Proposed erection of detached building with detached garage at
Occupation Road, off Birkby Road, Birkby, Huddersfield, HD2 2ES
(application 2024/90461)

I am acting on behalf of the residents of 5, Birchroyd Close, Birkby in their objection to the above application.

**1** Ground Floor  
Scale - 1 : 50

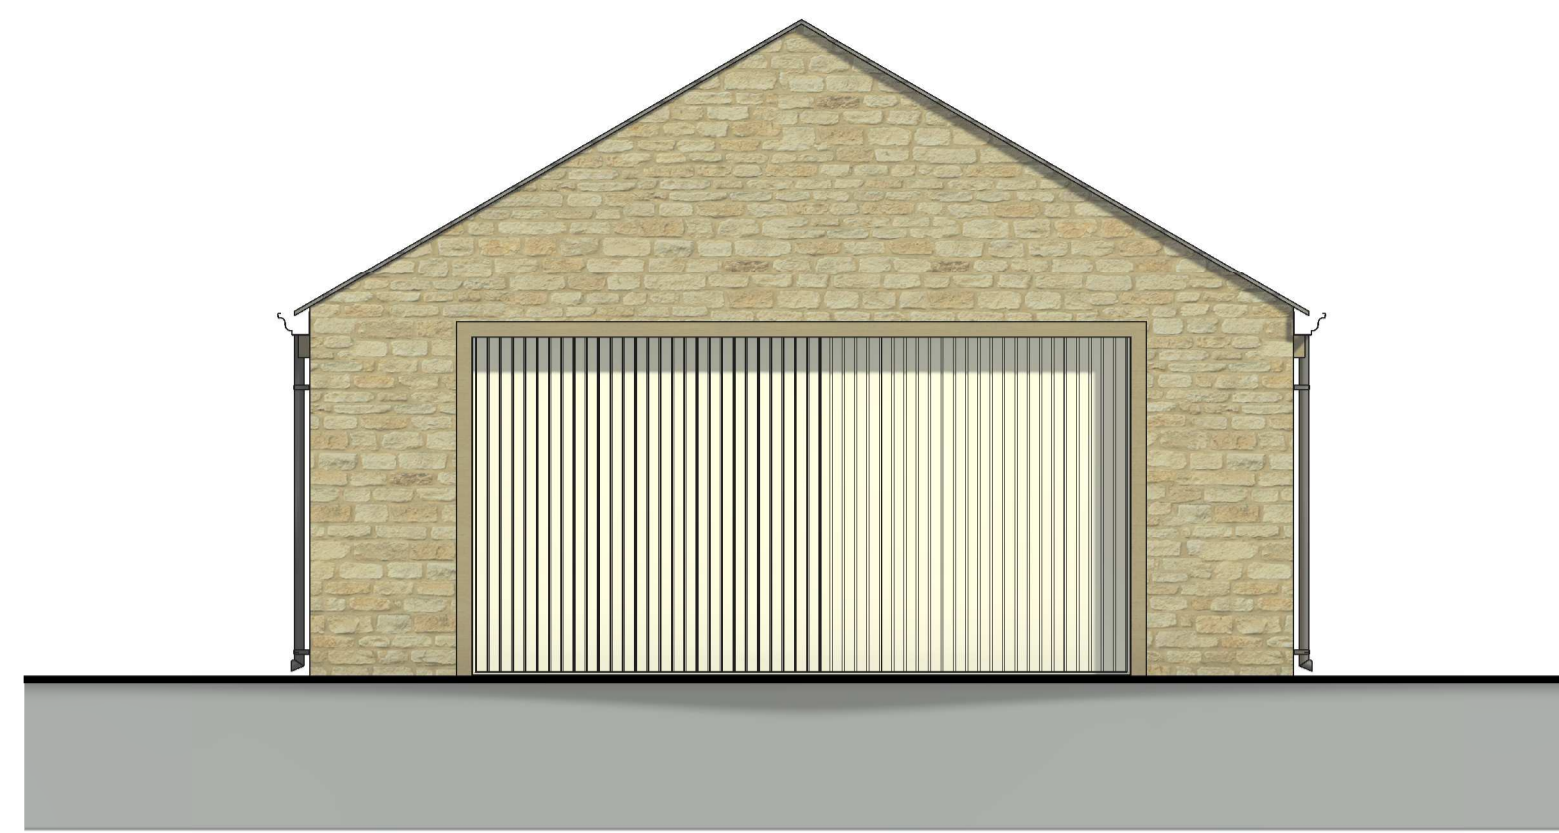
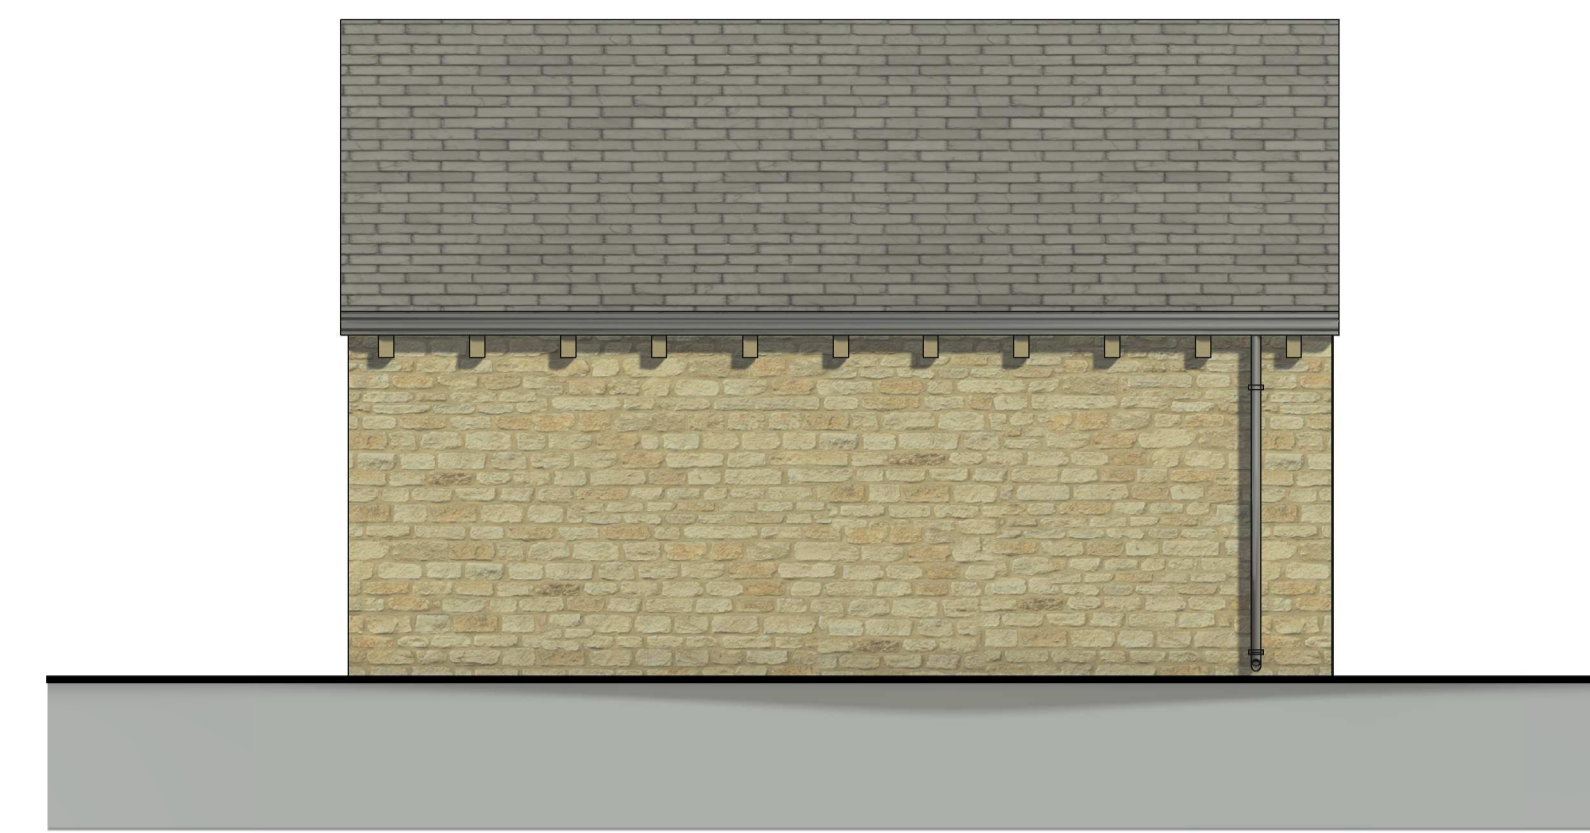
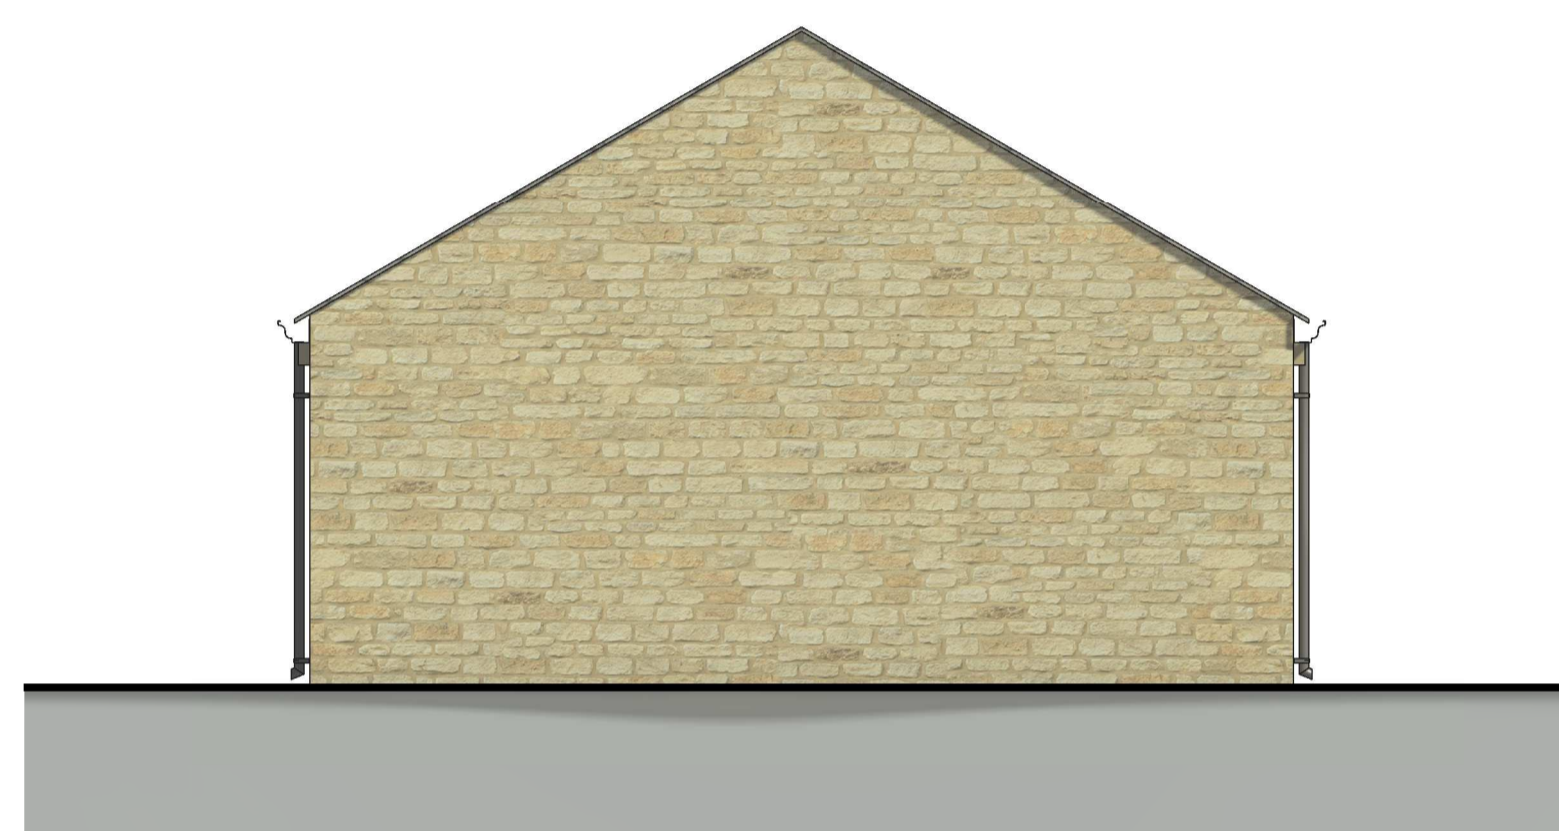
1) A cramped form of development – the width of the site is extremely narrow being constrained on its eastern side by leylandii hedging approximately 6 metres high and on its western side by the access track.

The proposed dwelling will occupy virtually the full width available resulting in a contrived and incongruous layout and design contrary to

3) Undue Impact – the proposed dwelling will have an overbearing impact on the outlook from No. 1 Birchroyd Close and will result in unacceptable overlooking of the rear garden and windows of No. 3 Birchroyd Close.

4) Undue Shading – Insufficient light will enter the proposed living room and main bedroom as the proposed main windows are north-facing, because of the high boundary hedge and because of the early mature Norway Maple in the rear garden of 3, Birchroyd Close (whose adverse impact will only increase over time, especially when in leaf).

Appendix 5: Tree Constraints Plan

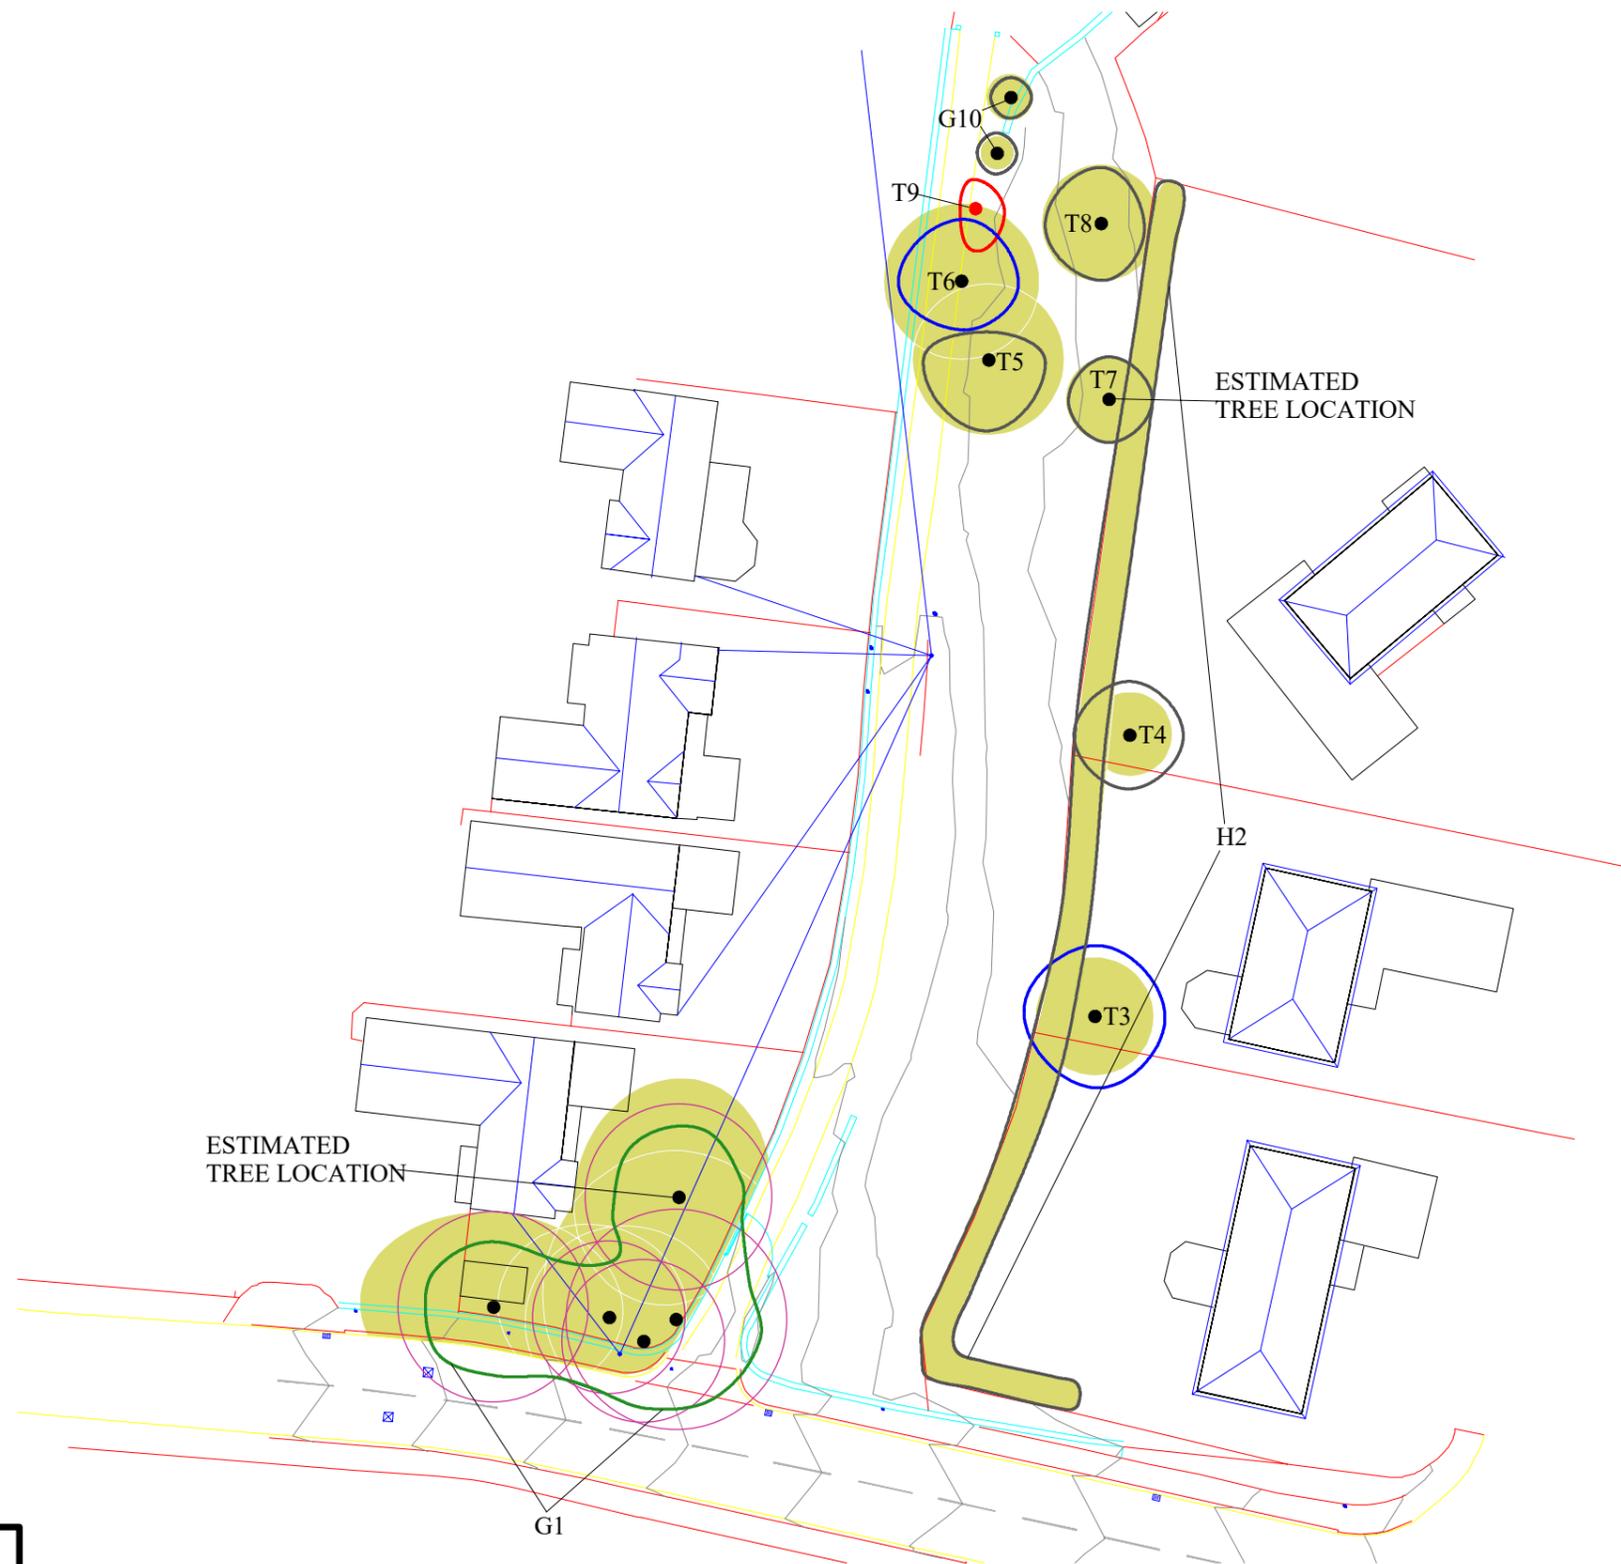
5) Protected trees – the trees in the garden of 360, Birkby Road are protected by a Tree Preservation Order. The works proposed to improve the access will likely adversely affect the roots of 3 No. of those trees.

No arboriculture impact assessment has been submitted to show that the works to improve the access will not have an adverse impact on the health of those trees which enhance the visual amenity of this part of Birkby Road.
